Subject: Fused Elements Residence  
Building Permit  
Second Round Issues and Comments

#### **PERMIT COMMENT RESPONSES**

DESIGN SECTION 17' Tall Wall With Tiebacks

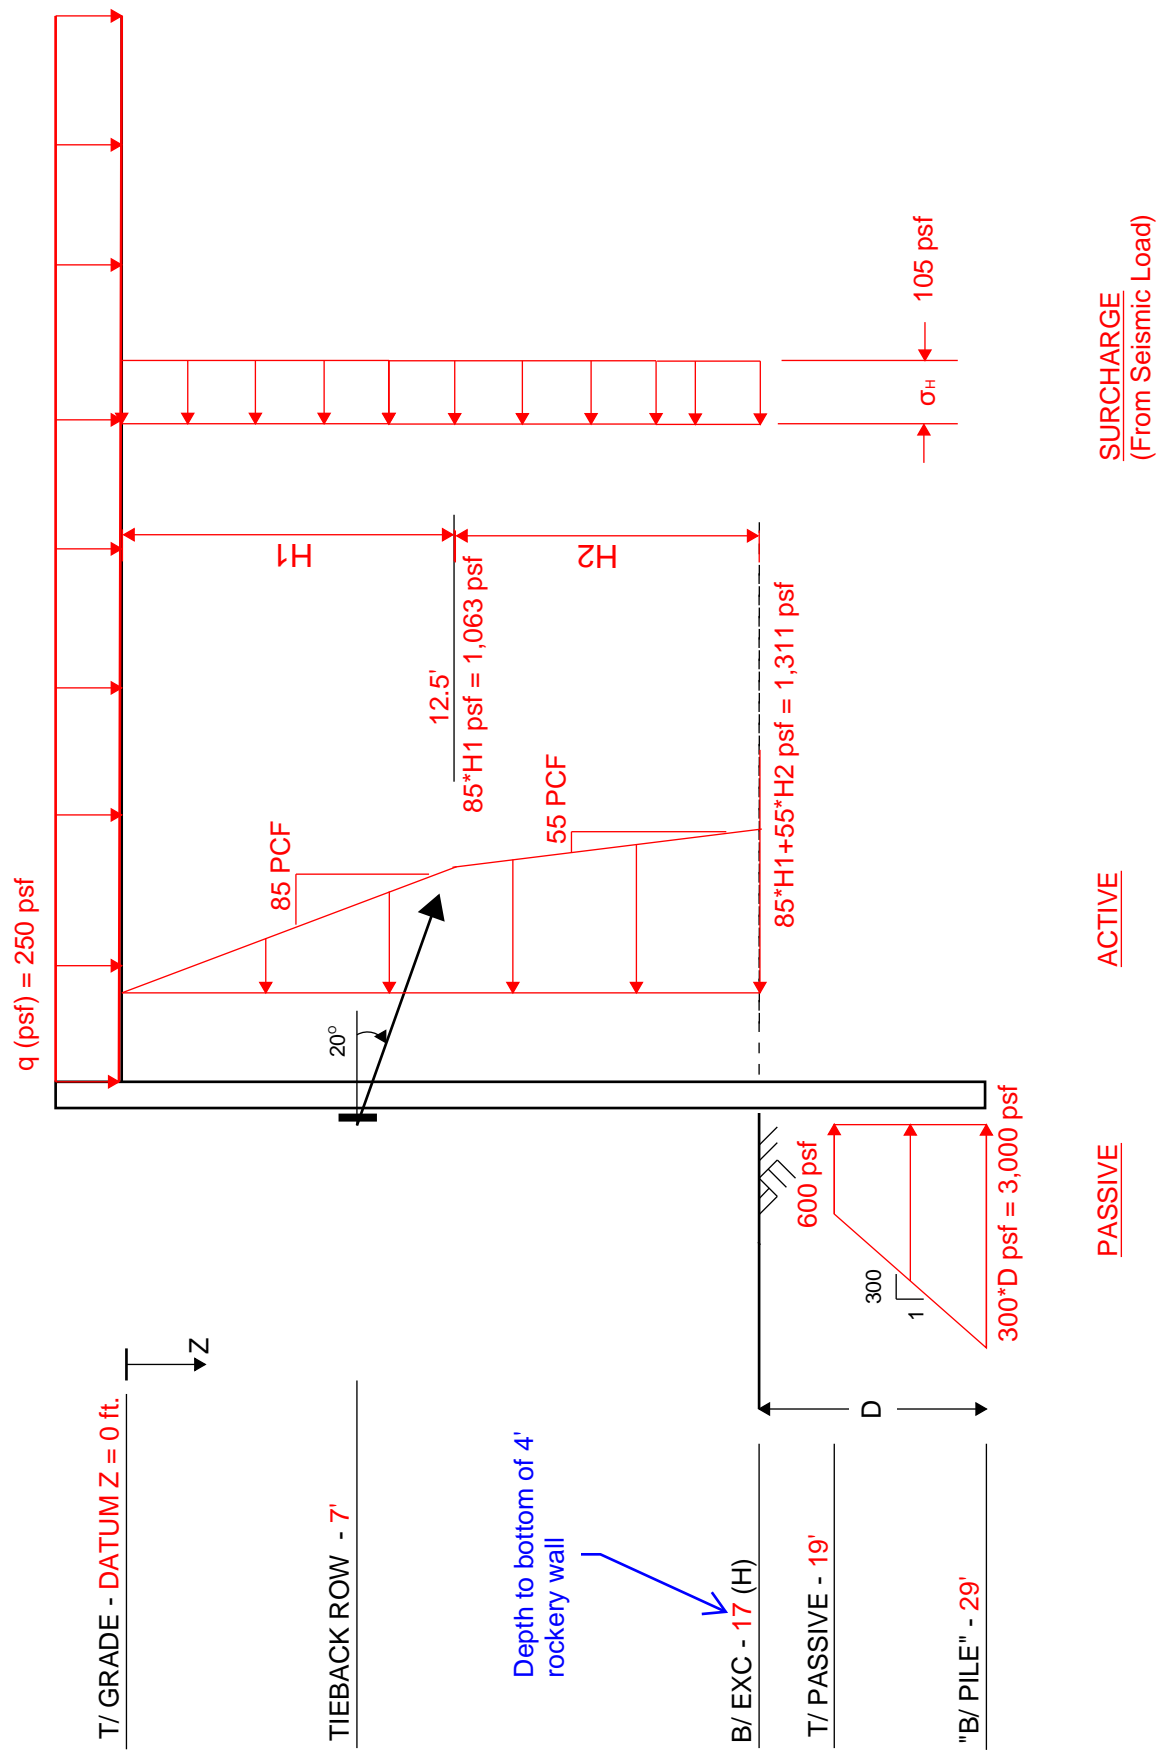
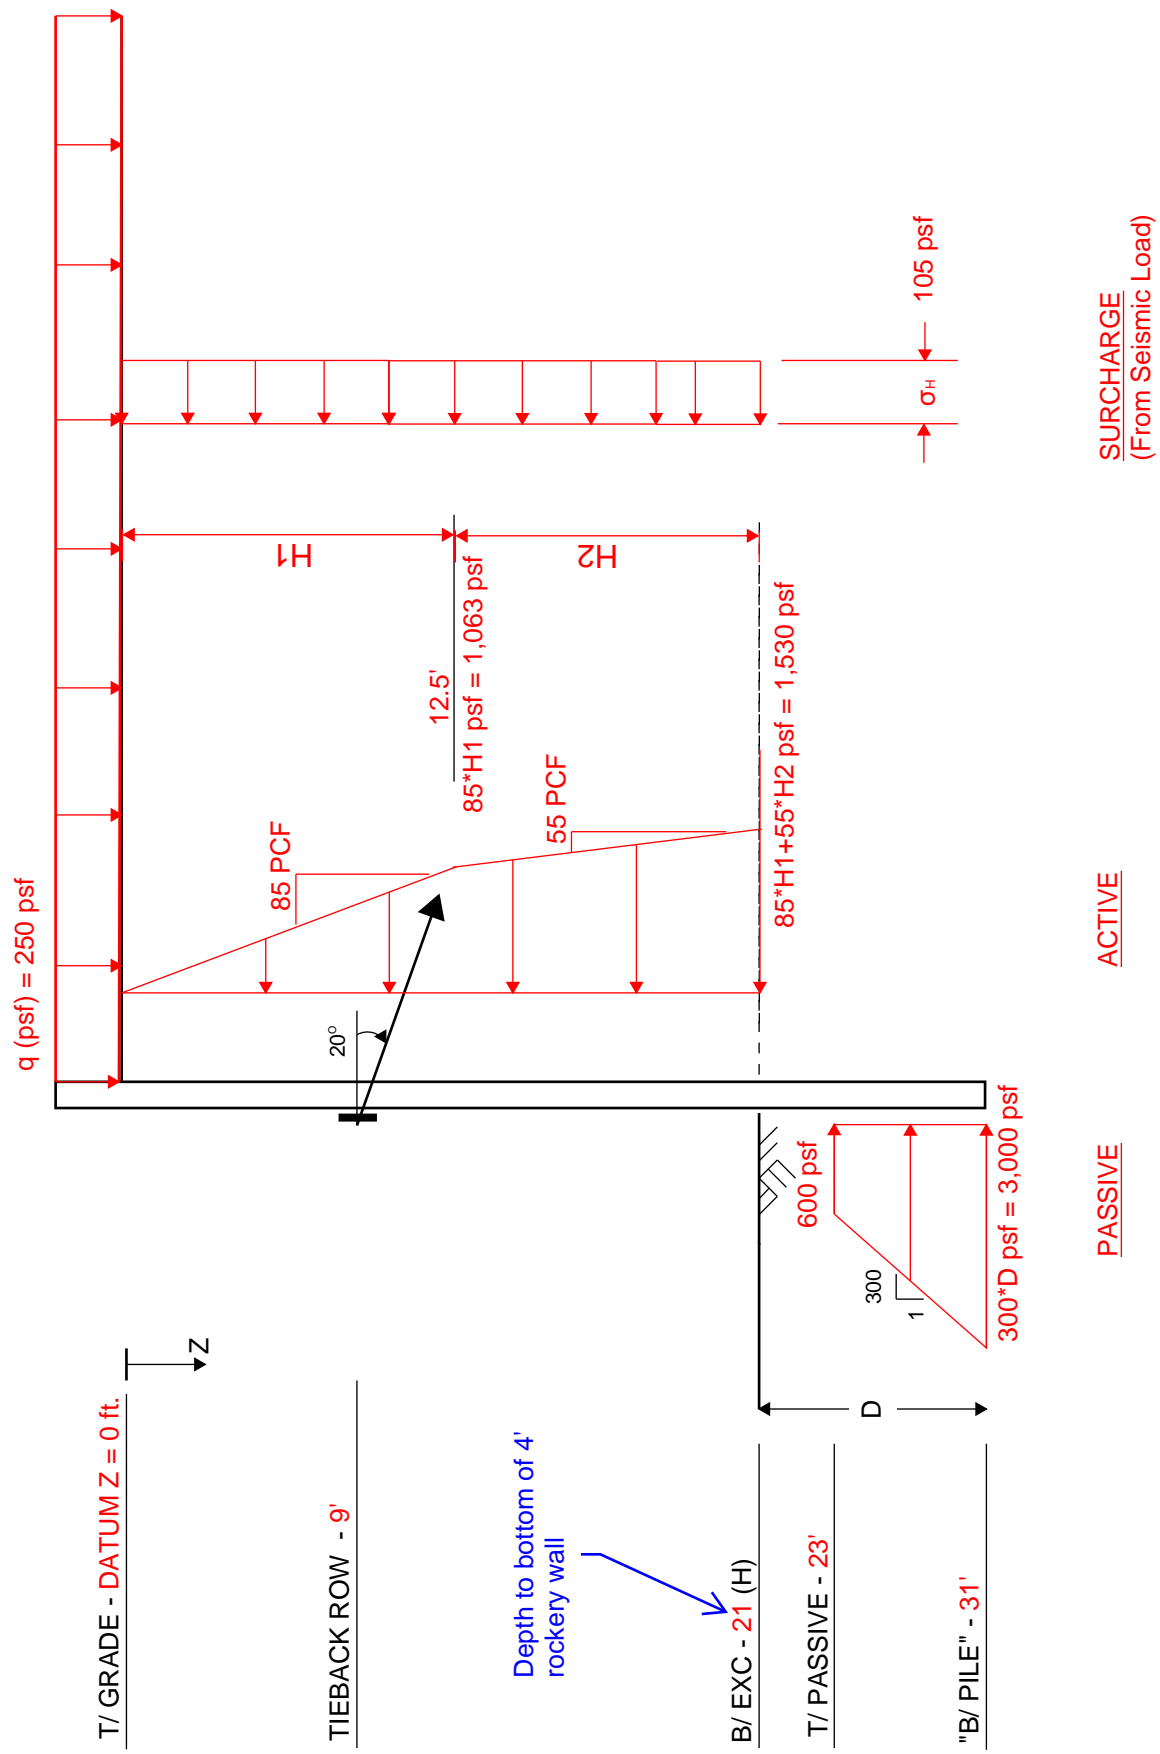
- 1. Comment: SH0.01 – In reviewing the structural calculations for the permanent soldier pile wall, no seismic loading was noted. The geotechnical engineer recommended 5H psf for active wall conditions and 10H for restrained wall conditions under seismic loading.*

**Response: Please see attached Supplemental Structural Calculations for analysis of shoring walls with seismic surcharge load included. These walls are considered unrestrained and therefore the 5H pressure is applicable. No change to the pile design is required, but a slightly larger tieback design load is required at the 21' wall. This revision is shown in schedule 19/SH4.01.**
